Consultation Response from: KC Environmental Health (Pollution & Noise Control)
2025/92743 - adj, 17, Hillhouse Lane, Fartown, Huddersfield, HD1 6EF
Variation of condition 13 (hours of operation) on previous permission 2019/93483 for erection of 4 A1/A3 ground floor units, 3 B1 offices and ancillary space, a free standing ATM and car park to vary the hours of use for units 1 and 2.
Date Responded:
Monday, 27 April 2026
Responding Officer:
HK
Responding Ref:
WK/202608934

(Picture 3)

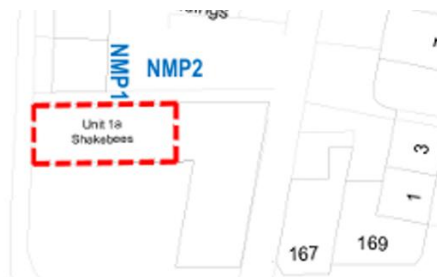
The measured noise level of the “*Unsilenced Air Intake*” was identified as 56dB L_{Aeq}. However, as can be seen in the above ventilation extraction system (Picture 2), the air intake and the ventilation extraction system are not the same equipment. It is not clear where the “*Unsilenced Air Intake*” is positioned in relation to the noise monitoring positions or the nearest residential receptor. However, as can be seen in picture 2 (above), it is the ventilation extraction system that is within close proximity to the noise sensitive receptor that poses a potential noise impact.
